Date: February 13, 2023

Response to Comments

Project Name: Sather-Vaness Sewer Main
 Project File Number: PA22-048
 Review Completion: January 24, 2023 and January 18, 2023

SHEET
C6 of C7
24x36

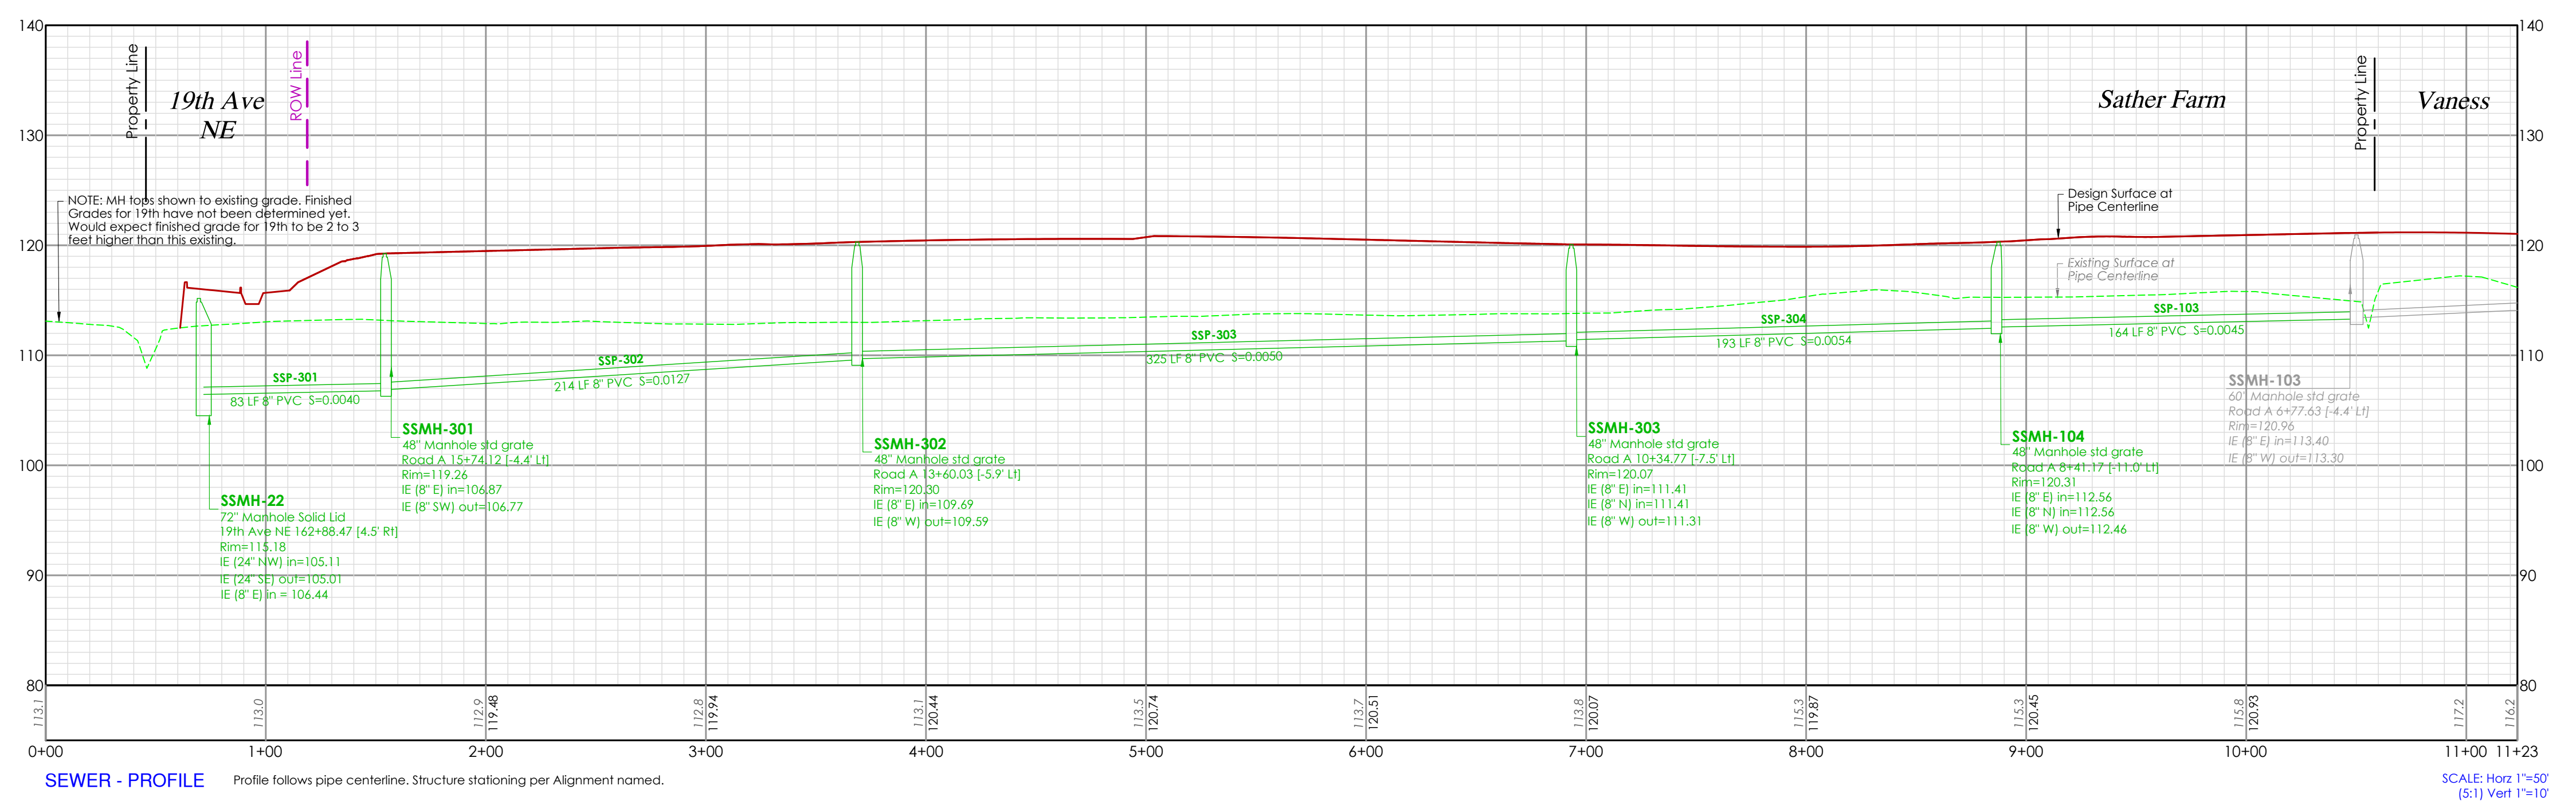
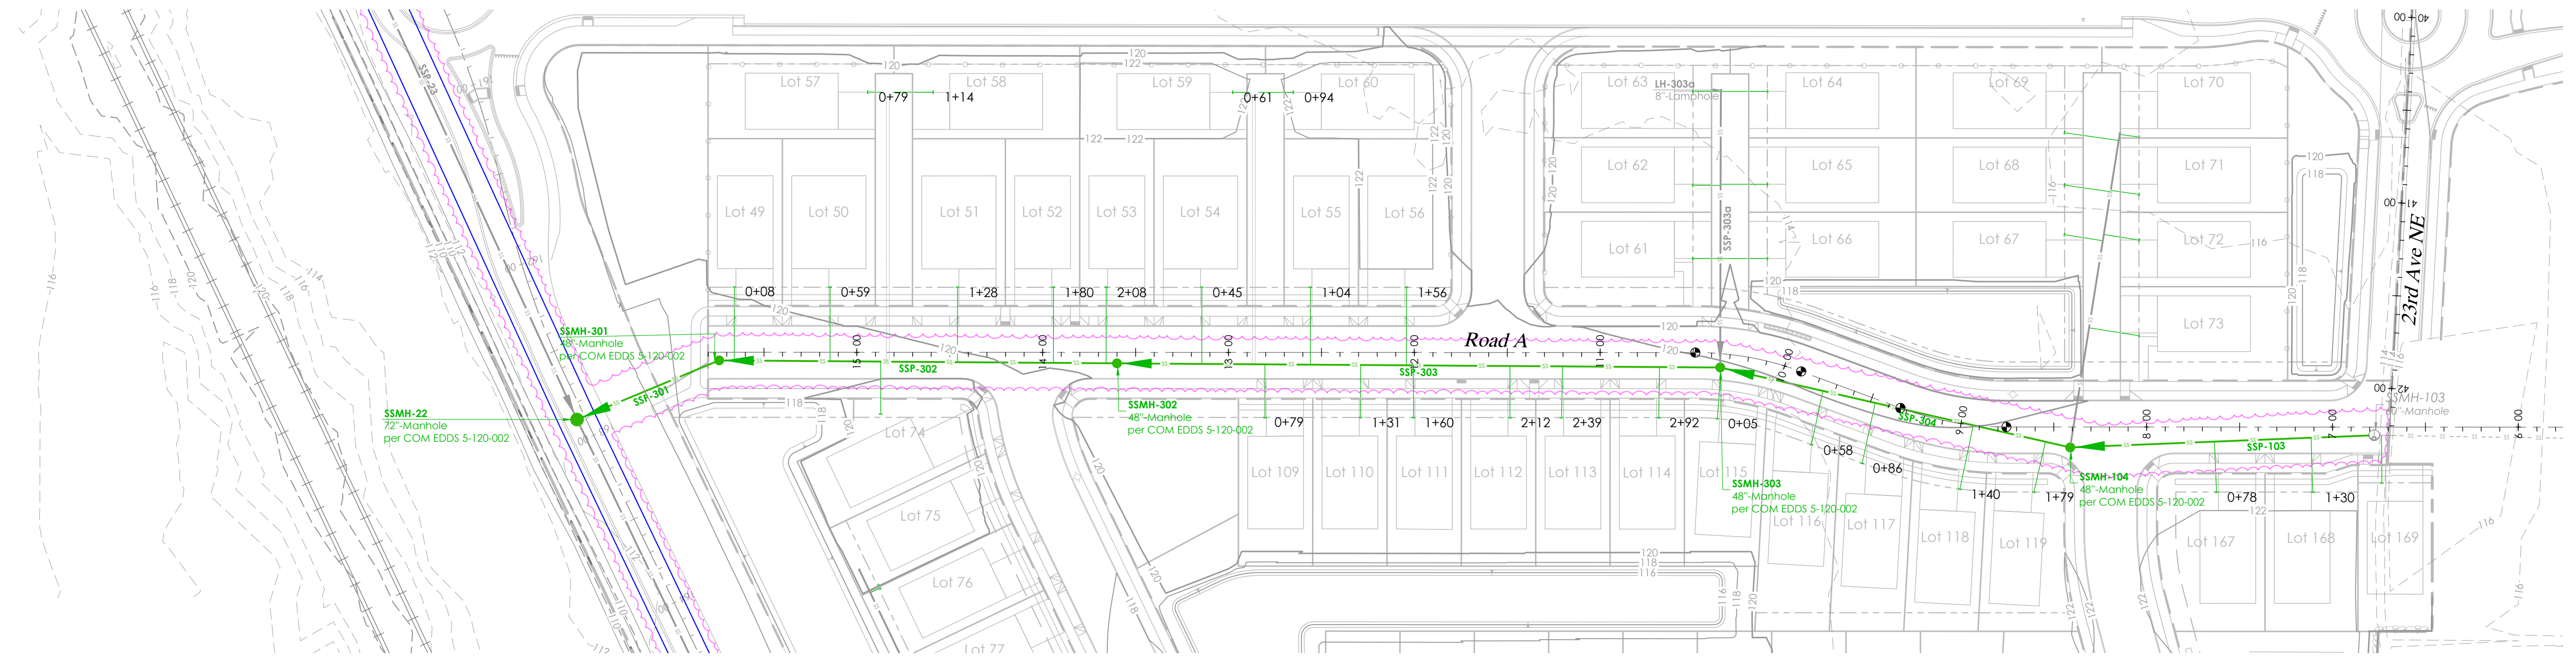
Sheet S6	
I'm aware that the Marysville 172 project will likely be tying into this line. If this is the case please show the plausible connection point.	Possible future connection has been added on S6 and labeled with IE connection.
